**Consultation Response from KC,
Lead Local Flood Authority**

**2023/93667 Storthes Hall Student Village, Storthes Hall Lane, Kirkburton, Huddersfield, HD8
0WA**

**Outline application for demolition of buildings and erection of residential development (up to
261 dwellings), redevelopment of Lodge Cottage for residential use and associated works**

Date Responded: 24th March 2024

INDICATIVE MASTERPLAN - STORTHES HALL, KIRKBURTON

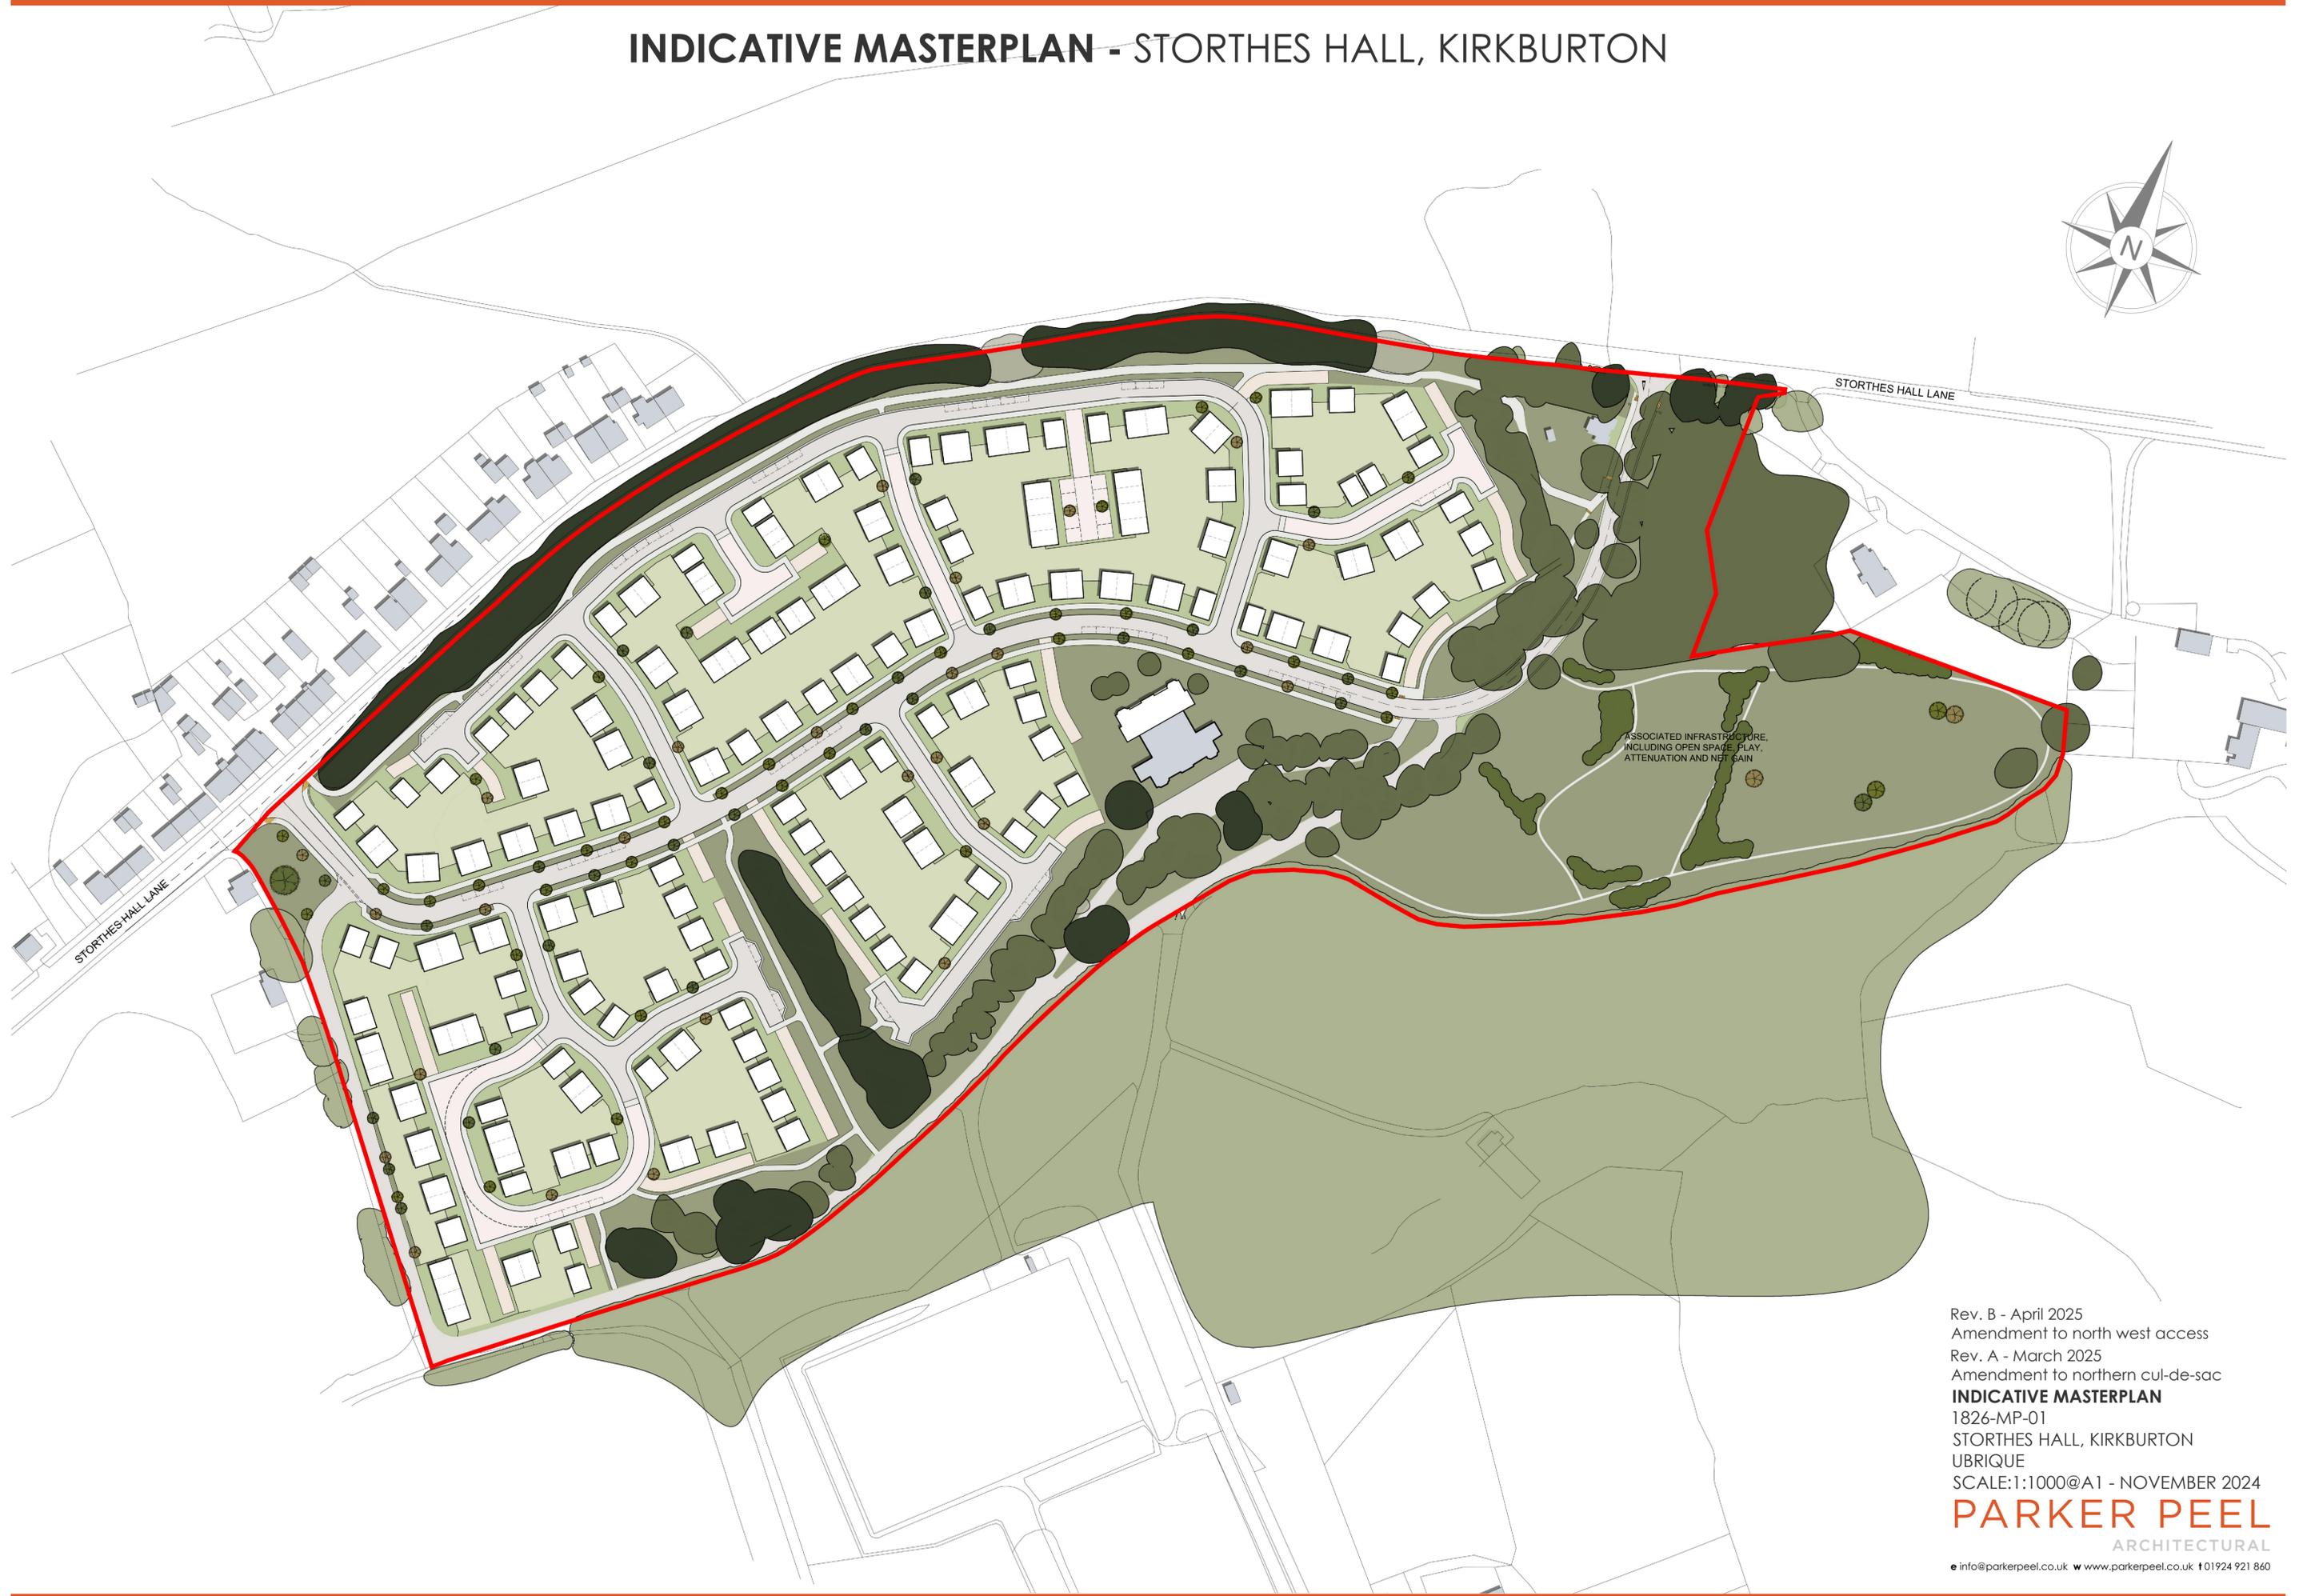
It is clear that flood routing has not been taken into account in the design of the layout. The design included low spots on roads next to properties that does not protect curtilages from flooding. An improved flood routing drawing is required that shows clear plot numbers (different numbers overlay each other which makes commentary difficult), measured contours on all roads, cul-de-sacs and parking areas (some contours carry no measurement).
